**APPLICATION BY LIVERPOOL BAY CCS LIMITED FOR AN ORDER GRANTING DEVELOPMENT CONSENT FOR THE HYNET CARBON DIOXIDE PIPELINE SCHEME**

**ENVIRONMENT AGENCY DEADLINE 8 (12<sup>TH</sup> SEPTEMBER 2023) SUBMISSION**

**NATIONALLY SIGNIFICANT INFRASTRUCTURE PROJECT – HYNET CARBON DIOXIDE PIPELINE**

EN070007-D.2.2-LP-Sheet 3

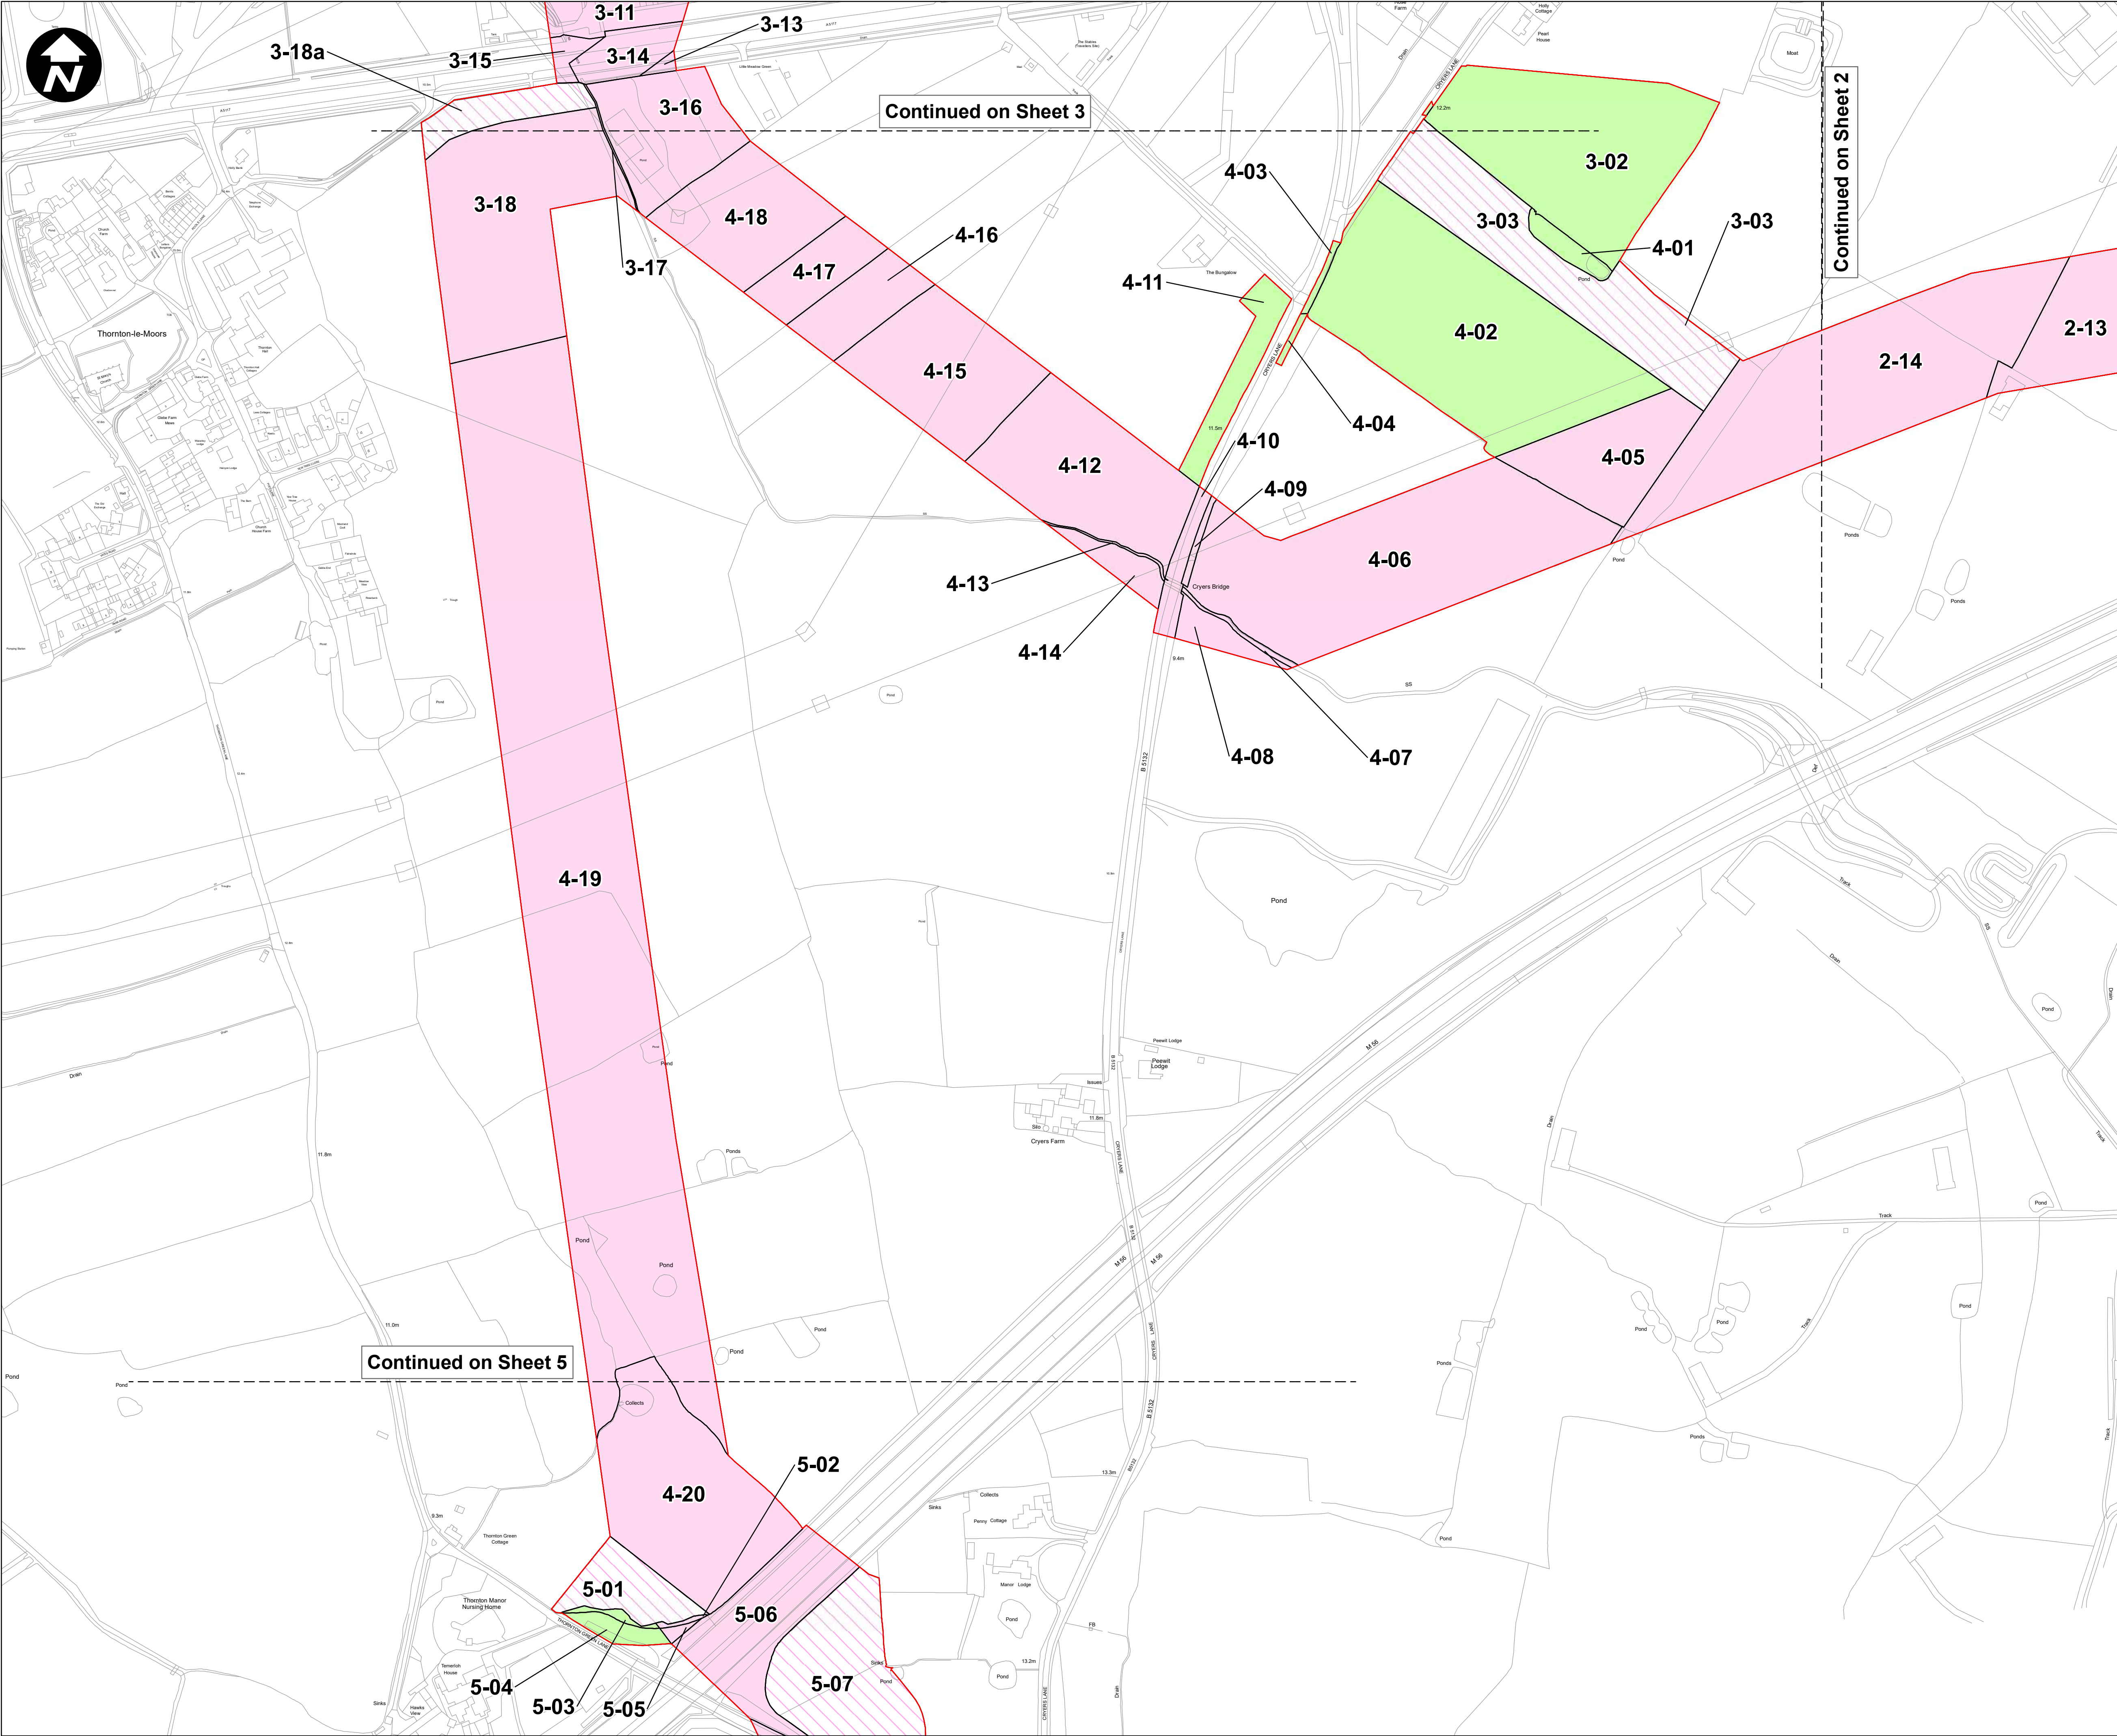
With regards to the Stanlow Manufacturing Complex, we note the Applicant has included under DCO Requirement 9 Part A [REP7-013] [REP7-014] a specific requirement for Land plots 3-11; 3-12; 3-13; 3-14 and 3-15 [REP7-008]. The proposed approach has been established due to the likely ground conditions and the permitting matters associated with the current site operator.

Further to the above, we do not agree with the focus on land plots 3-11, 3-12, 3-13, 3-14 and 3-15 [REP7-008] in this area. Having reviewed the Land Plans [REP7-008], we have identified further land parcels (3-04 to 3-10) within the Stanlow Manufacturing complex which will likely be impacted by historical contamination. We note the Applicant has not considered these Parcels within the Ground Investigation Technical Report [REP7-293]. Therefore, additional site investigation work and assessment would be expected to establish site conditions and determine whether remedial works are necessary in this area.
